# CITY OF ALBUQUERQUE

April 25, 2017

2400 Marie Park

**Re: Drainage Ordinance (14-5-2-1) Violations for Erosion and Sediment Control**

Silt Fence

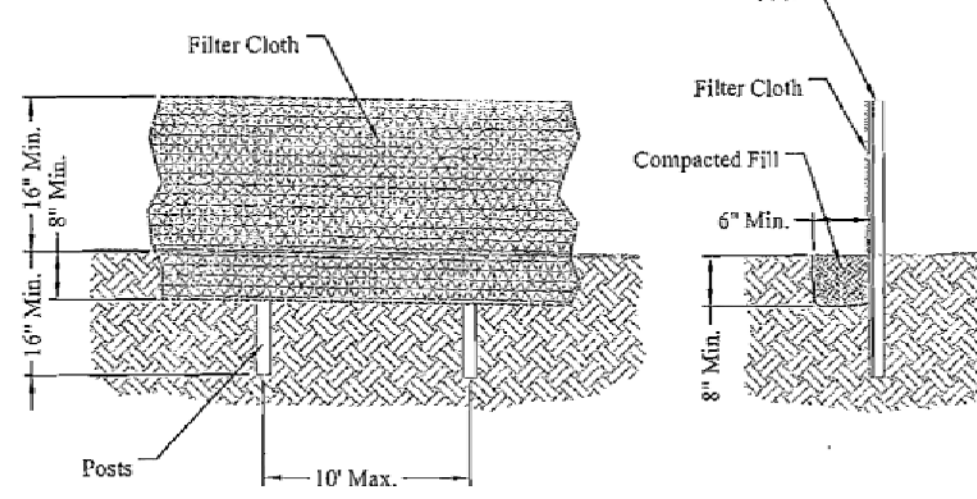
1. The silt fence installation could use some improvements/reinstallation for the following reasons:
  - a. Wood posts not strong enough.
  - b. Silt fence not buried in numerous locations. Please pay extra attention to the SW and NW corners as they appear to be drainage outfall locations.
  - c. There were gaps in the silt fence.

1. Install/reinstall silt fence per approved methods along Marie Park Dr., along Menaul Blvd a minimum of 30 feet east of Marie Park Dr and along north edge of the site from Marie Park Dr. to the wall shown in the last photo. See approved ESC Plan for details.

Erosion Sediment Control Plan

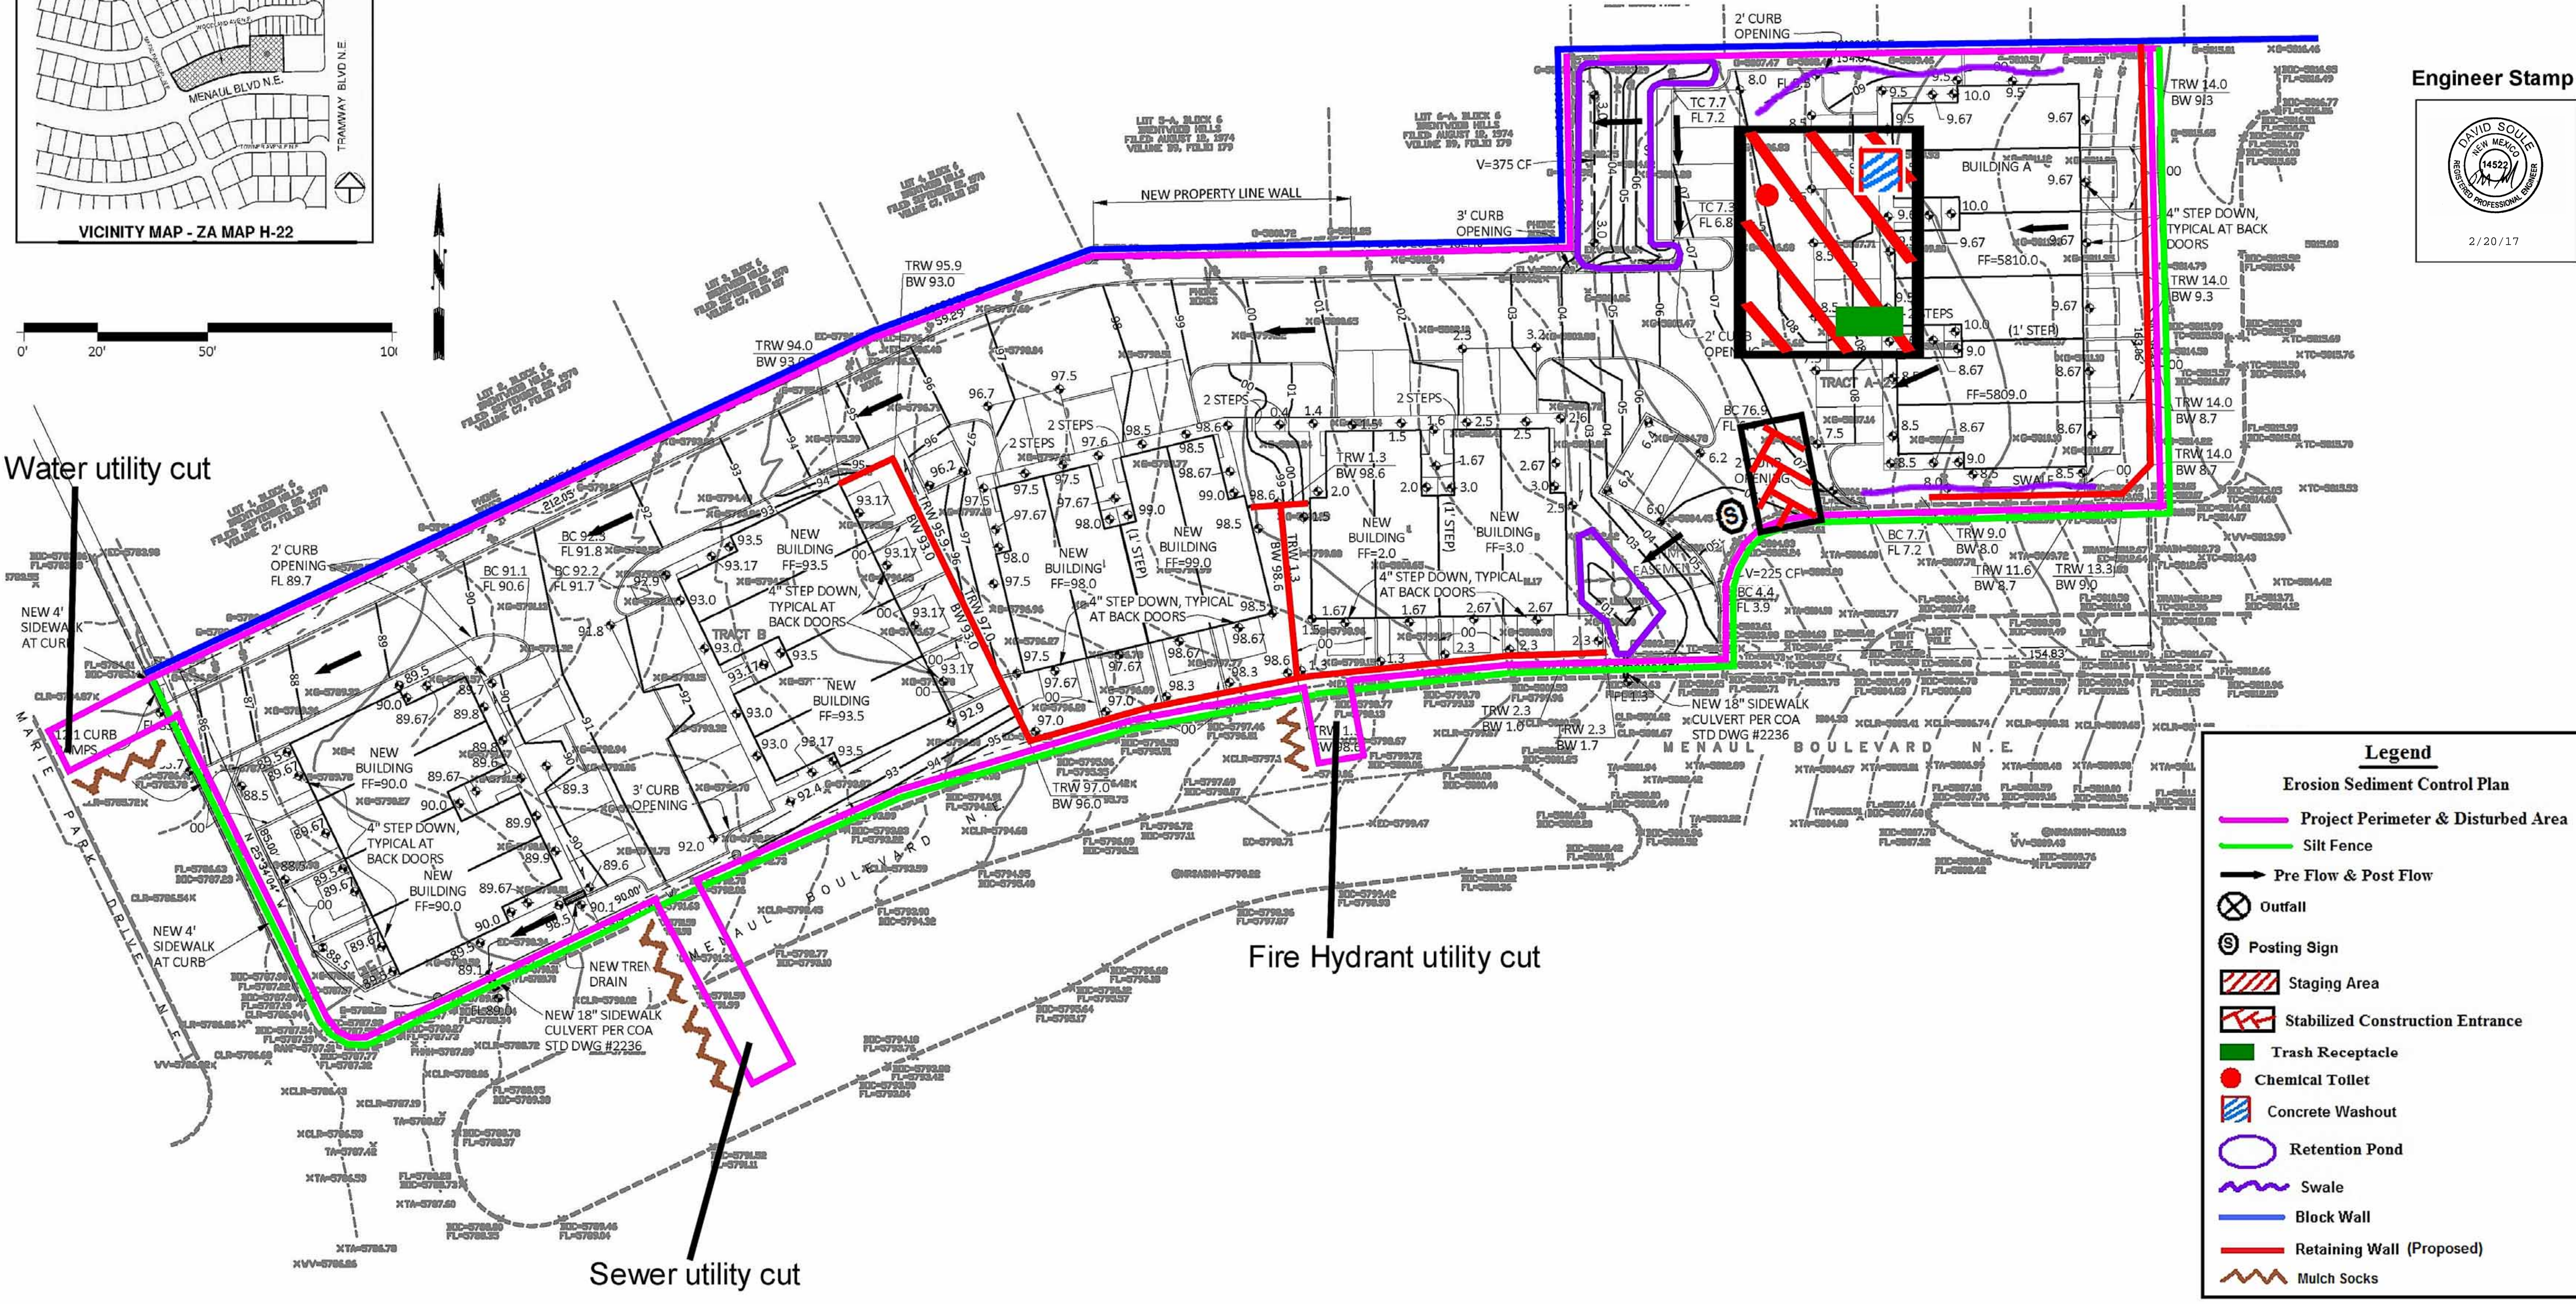
At today's inspection the berms were not graded as agreed upon and it was not clear that the wall work had begun.

Silt fence in southwest corner. No berm.

Gap in silt fence and silt fence falling down along Marie Park Dr. Dirt straight-graded to edge and no berm. Sediment observed in street.

Gap in NW corner. No berm.

2. Stormwater Quality will honor its verbal agreement, made on 4-18-17, to allow for a berm where the silt fence is not buried along Menaul Blvd, excluding the section discussed in number 1 above. However, if there is a delay (not completed within 30 days) in the construction of the wall along Menaul and acceptable sediment BMP shall be installed per approved methods.
